Your ref: 3/2016/0418

Date: 13th June 2016

Planning Application 3/2016/0418: Creation of 2 flats at first floor level and associated external alterations; 1 Moor Lane Clitheroe BB7 1BE

5085 - 03 A

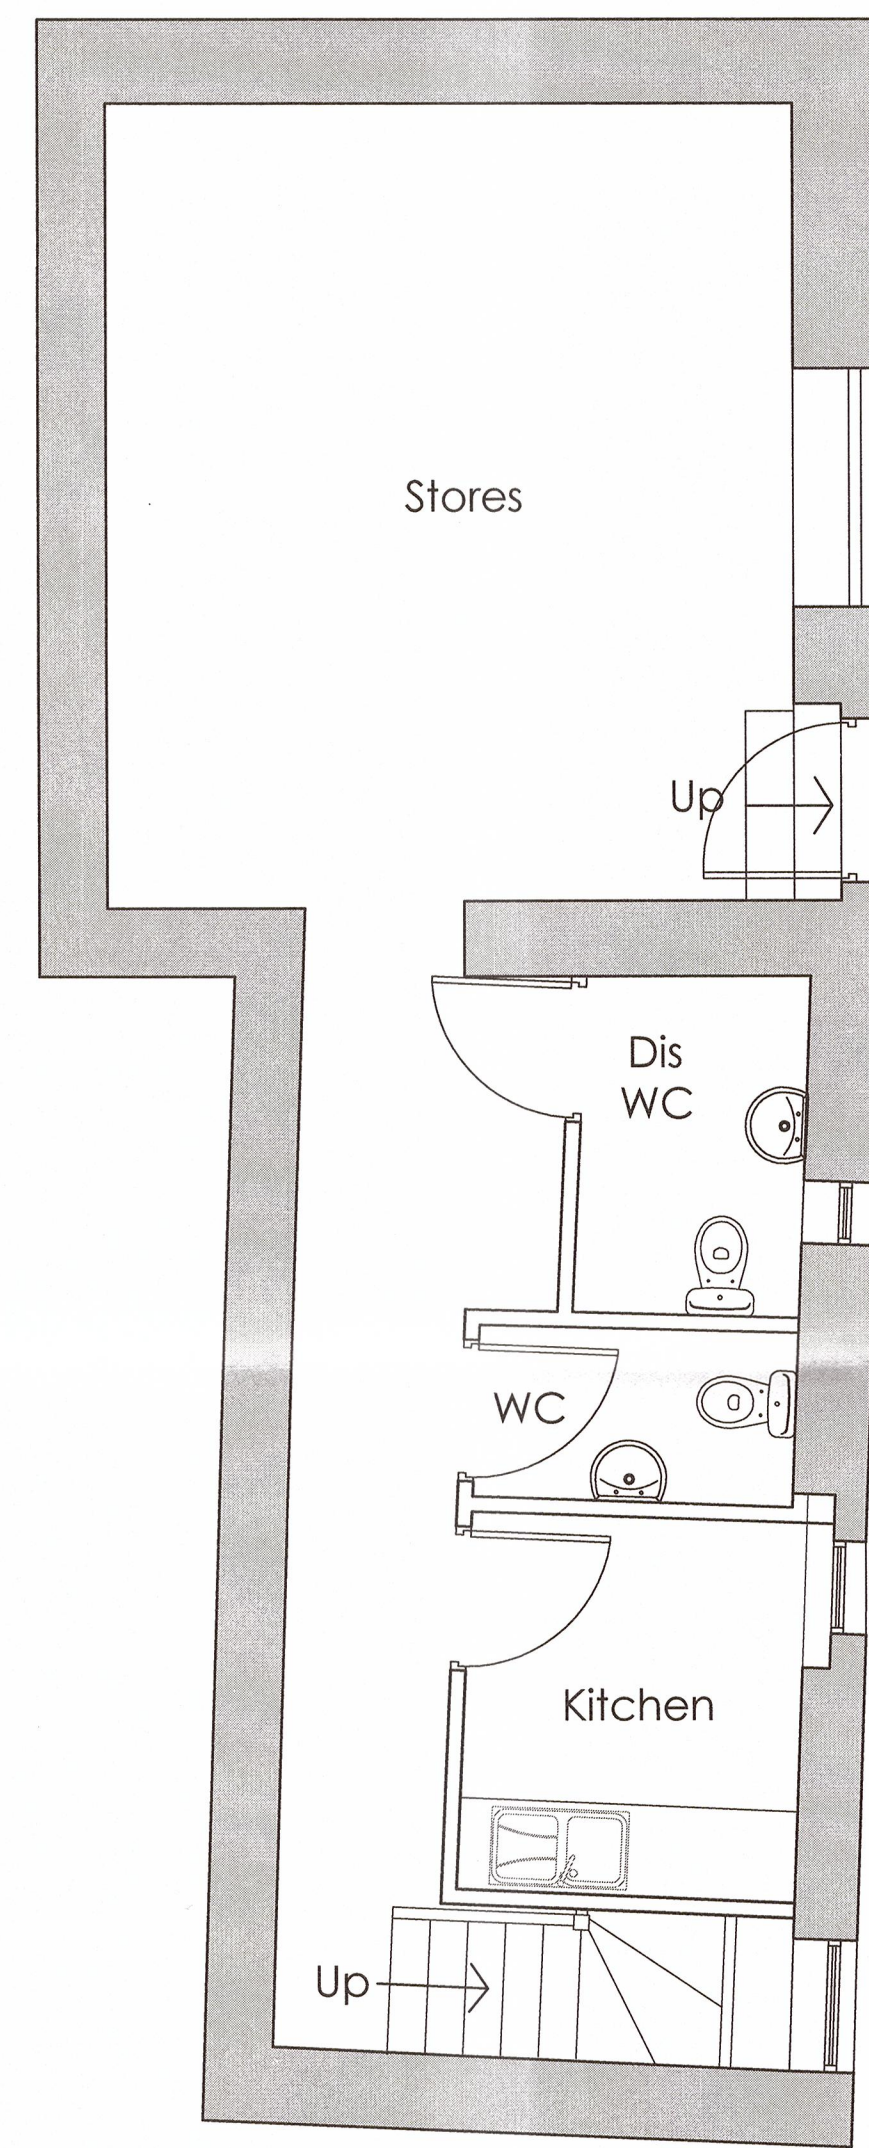
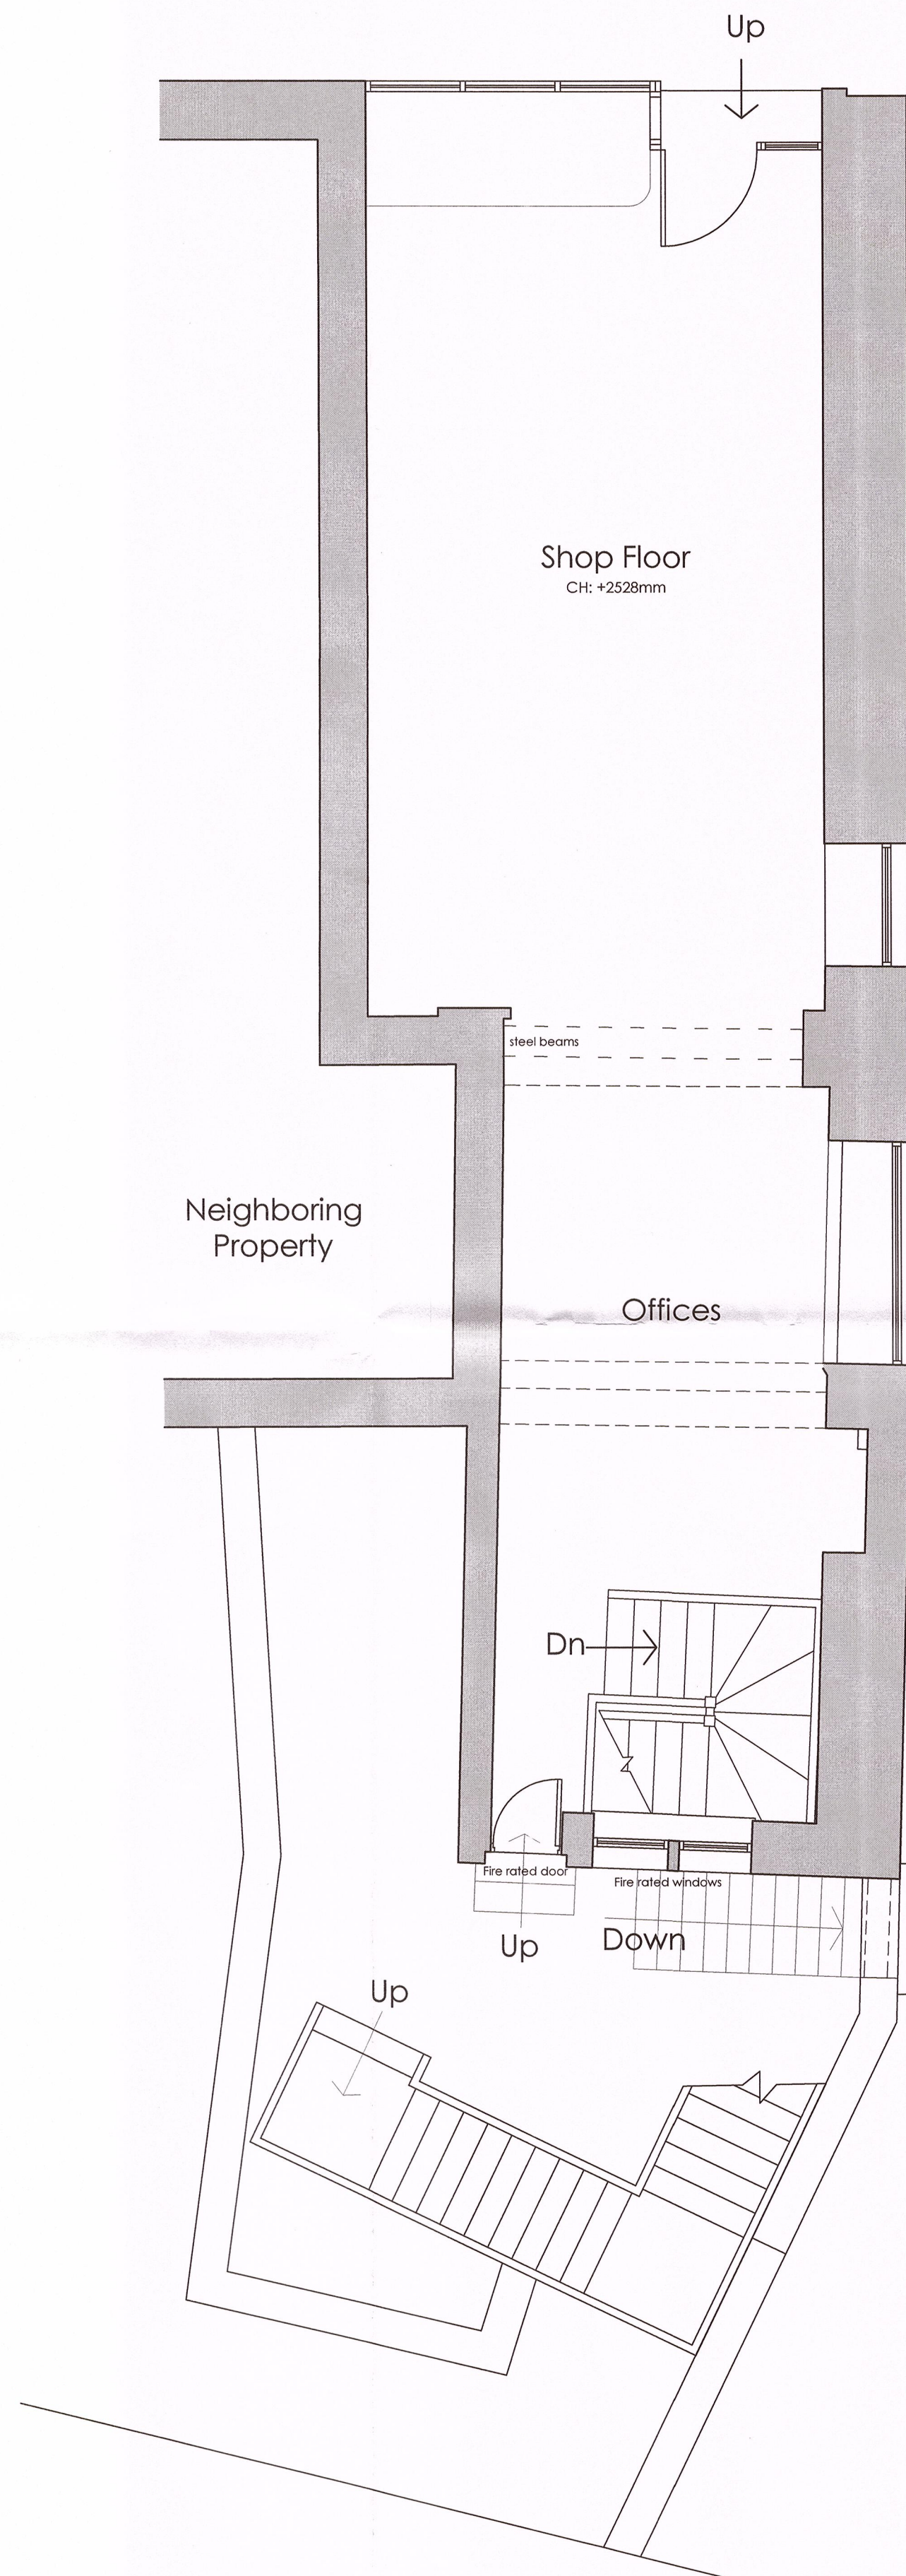
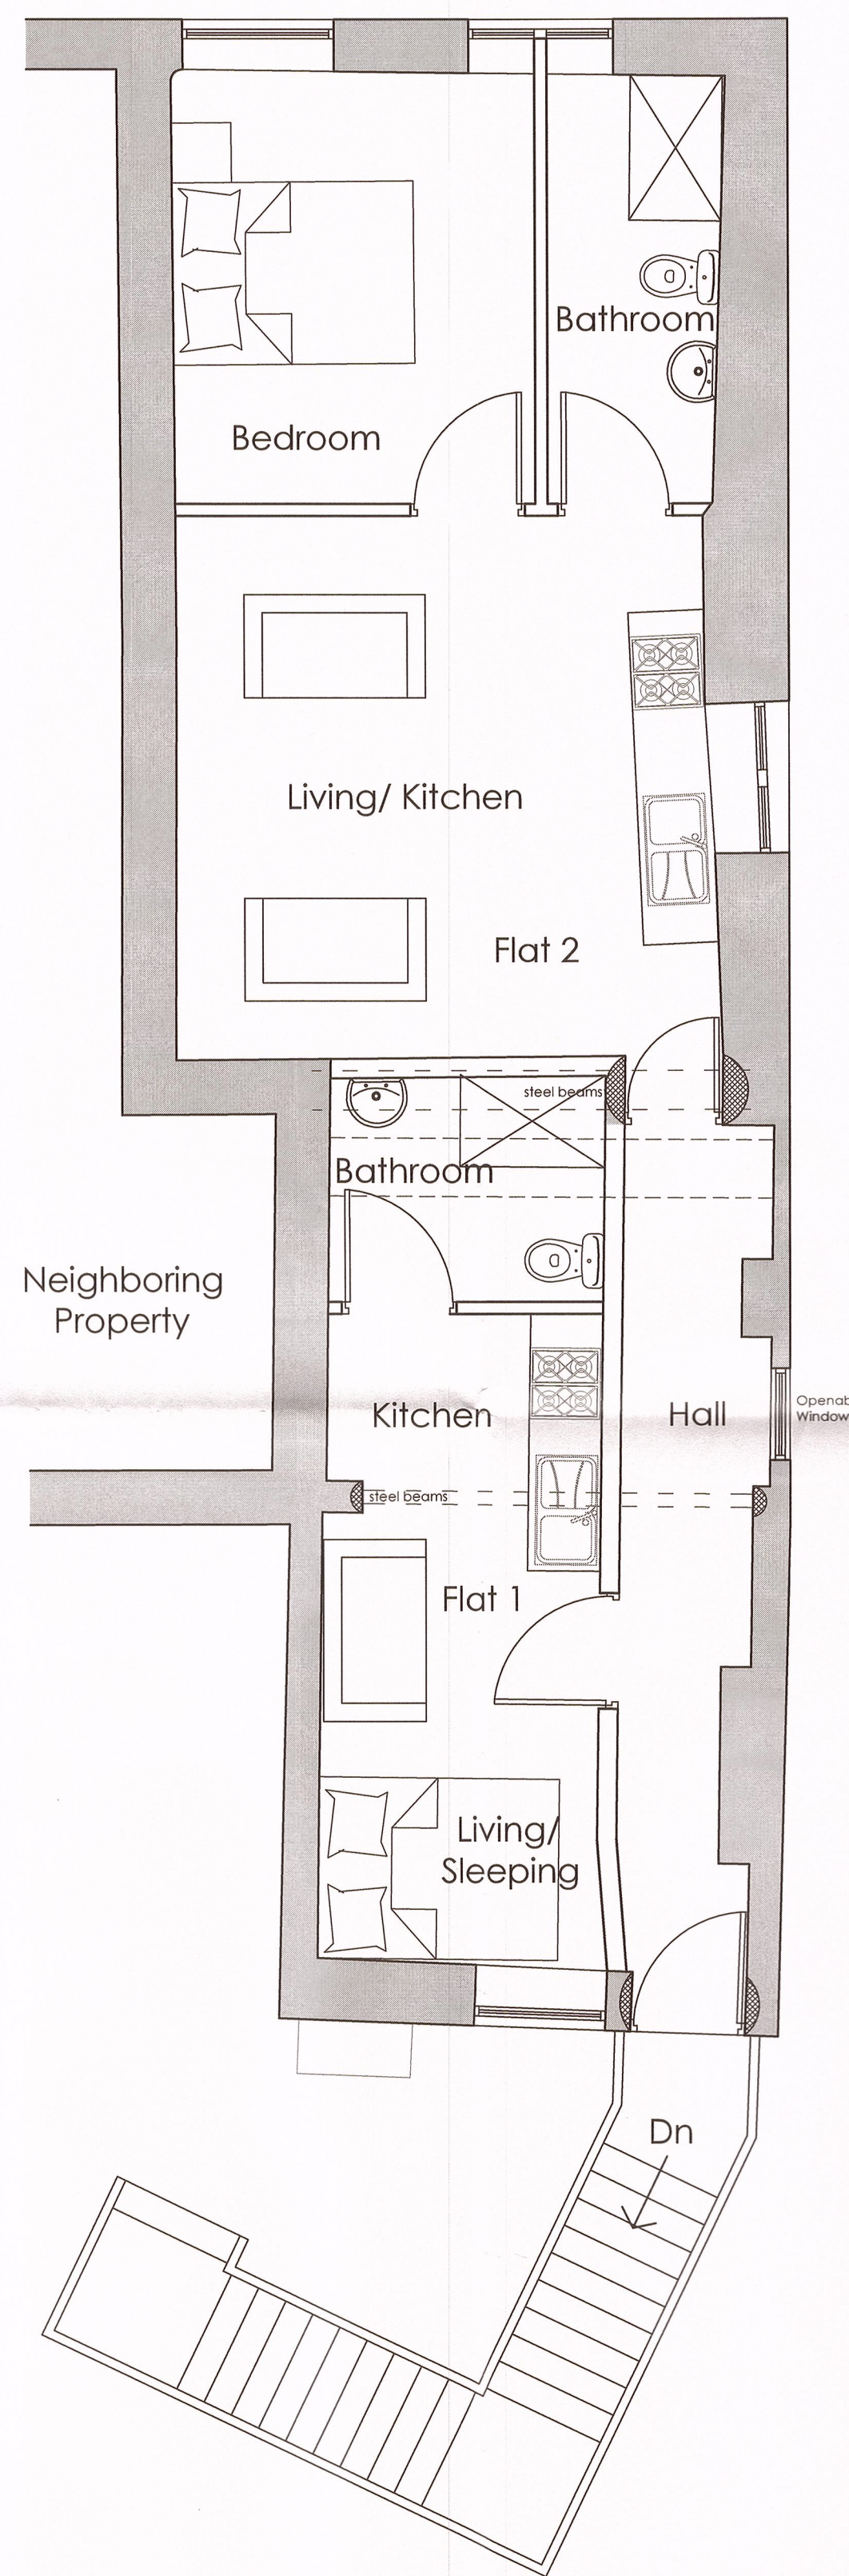
The proposed alterations are not severe in themselves, but the removal of an existing wall between the main shop body and a rear room on the ground floor and the removal of the same wall and a second on one the upper floor could impact on these earlier elements; it would certainly reduce the legibility of the existing building structure. In contrast the insertion of a new door into the upper part of the rear elevation seems unlikely to have such an impact on the understanding of the building, but when combined with the proposed new metal stair does have a much greater visual and aesthetic impact. This is particularly unfortunate when compared to the effort that has been expended upon the side of the church and hall on the opposite side of Strang Stee. The gain from this, of allowing the construction of two independent flats on the upper floor seems limited, particularly given the very small size of the accommodation units produced and an alternative solution which utilised an internal stair would be preferred.

Should the proposals receive approval, however, we would recommend that a formal record of the building be made prior to any alterations being made. This should concentrate on the areas where the changes are proposed and attempt to ascertain the relative dates and construction sequence of the rear elements, as well as looking for any early remains that may be incorporated in the structure and impacted by the proposals. This may be required by planning condition; the following wording is suggested:

Condition: No development shall take place until the applicant, or their agent or successors in title, has secured the implementation of a programme of recording, analysis and reporting. This must be carried out in accordance with a written scheme of investigation, which shall first have been submitted to and agreed in writing by the Local Planning Authority.
